From: Iain Osenton <iain.osenton@cherwell-dc.gov.uk>
Sent: 25 May 2021 18:23
To: George Smith <George.Smith@Cherwell-DC.gov.uk>
Subject: 20/01891/F - CDC Arboriculture
Importance: High

In response to the arboricultural appeal statement.

protection plan

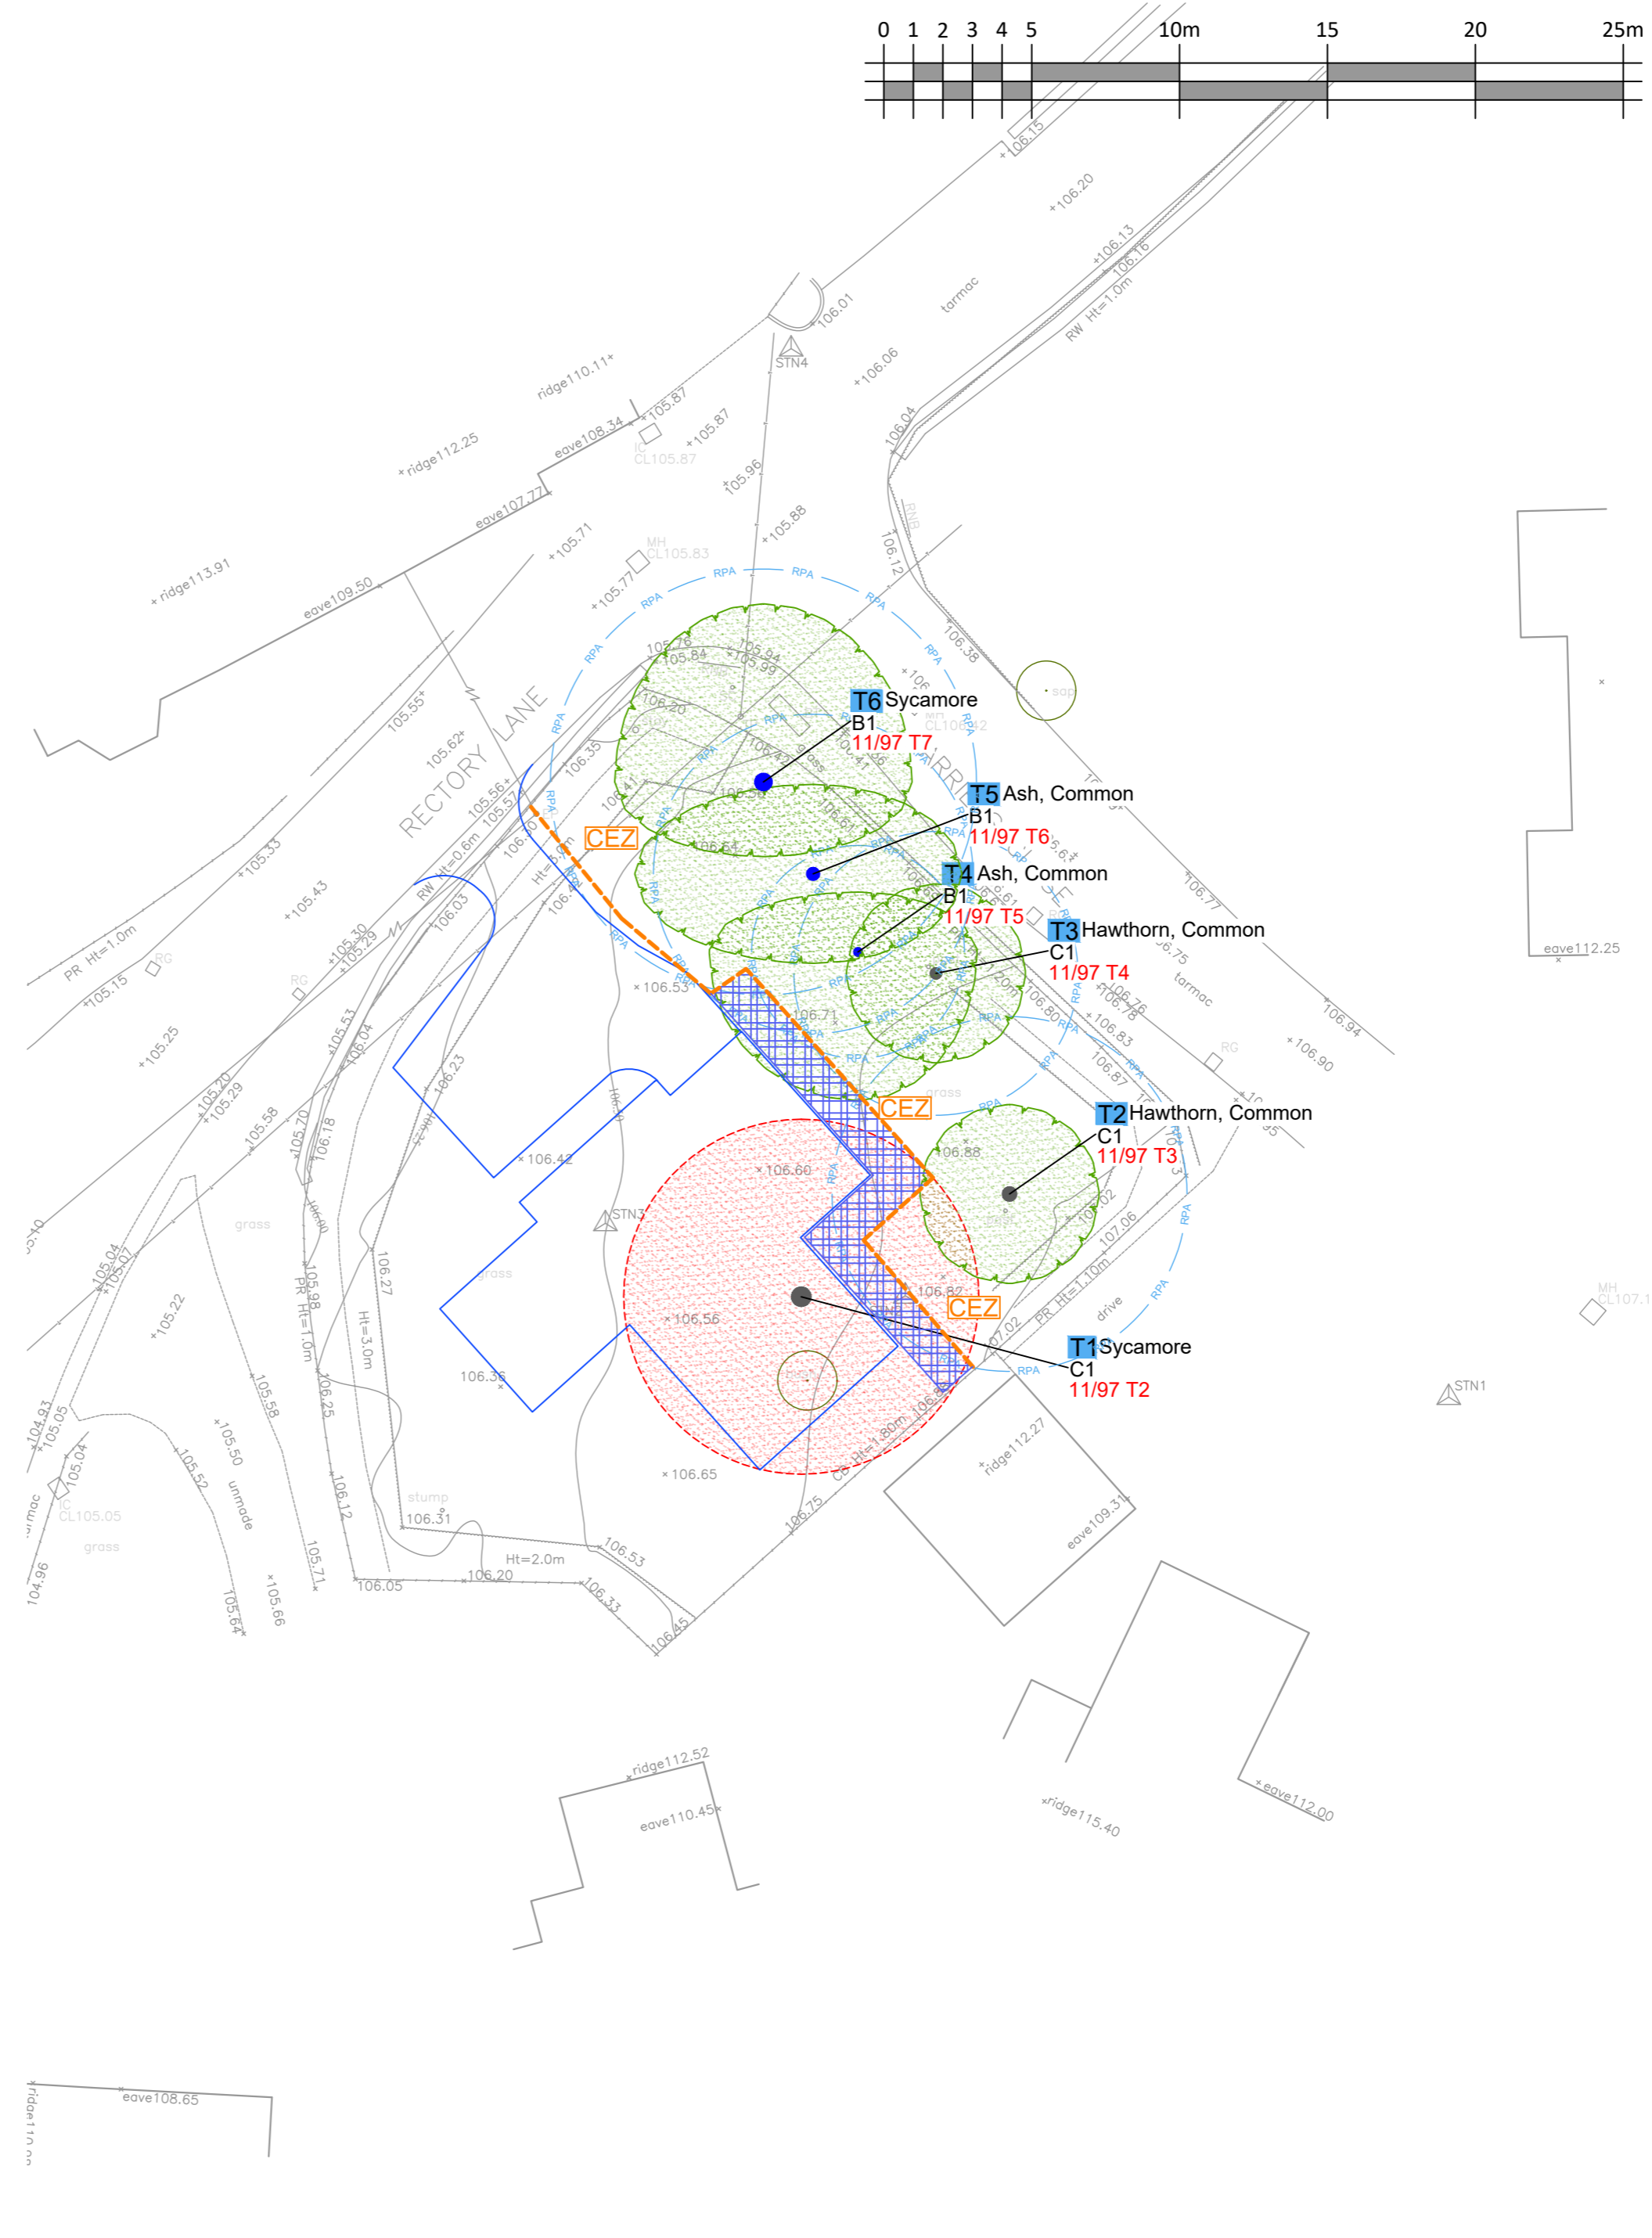
Primary concerns lie with the proximity of the proposal to the retained, protected trees, and the future conflicts this will present.

Whilst it is acknowledged T4 and T5 being *Fraxinus* spp. are vulnerable to Ash Dieback, there is no evidence submitted suggesting they are currently exhibiting symptoms. Therefore, in line with Forestry commission guidance, in that premature removal of ash trees is discouraged, I do not feel it is appropriate to overlook the potential long term impact these trees may afford to the proposal. The arboricultural survey schedule concurs with this, as it has awarded each tree an estimated 20 years of remaining contribution, and BS5837:2012 category B1.

Within the tree survey schedule, both trees have been categorised as mature, yet are recorded as holding a height of 14/15m, and stem diameter (DBH) of up to 350mm. This suggests considerable growth remains in these trees, which combined with a 1.5/2m current crown clearance, will inevitably result in above ground encroachment upon the north aspect of the proposal. In line with BS5837:2012 5.2(a) the proposal does not account for the ultimate height or spread of retained trees, therefore creating future conflict. The appeal states uninhabited buildings, such as garages present very little future pressure for pruning. On the contrary, BS5837:2012 does not give exemption for the proposed use of a building, as encroachment, including possible direct damage will regardless prompt frequent mitigative pruning.

Below ground. Whilst I have not submitted a soil sample for laboratory analysis, I have seen no evidence to suggest the applicant has either. BS5837:2012 5.3.3 highlights the importance of considering the sites soil structure when building adjacent to retained trees. Landis highlights the soil structure of the site as 'Soilscape 18, loamy and clayey, slowly permeable and seasonally wet'. This is the same category as the Langford area of Bicester. Which, sees frequent cases of subsidence as a result of seasonal, vegetation induced soil shrinkage. Concerns for future subsidence are not just applicable to T4/T5, as the accumulative effect of all trees, especially trees of a potentially very large ultimate height (T6) remain within influencing distance to the proposal.

BS5837:2012 equally highlights the potential for soil heave, should mature trees be removed from a shrinkable clay soil. Due to the proximity of the building adjacent to retained trees, it could be expected soil heave may present a future conflict with the proposal, unless foundations are designed with this as a consideration. In line with BS5837:2012 the proposal despite offering minimal facilitative below ground conflict, still offers potential short to long term below ground conflict.

In line with the above, despite the proposals acknowledged low facilitative arboricultural impact. Long term above ground conflict contrary to BS5837:2012 remains, with potentially short term conflict arising should foundation design not account for the proposals proximity to retained trees.
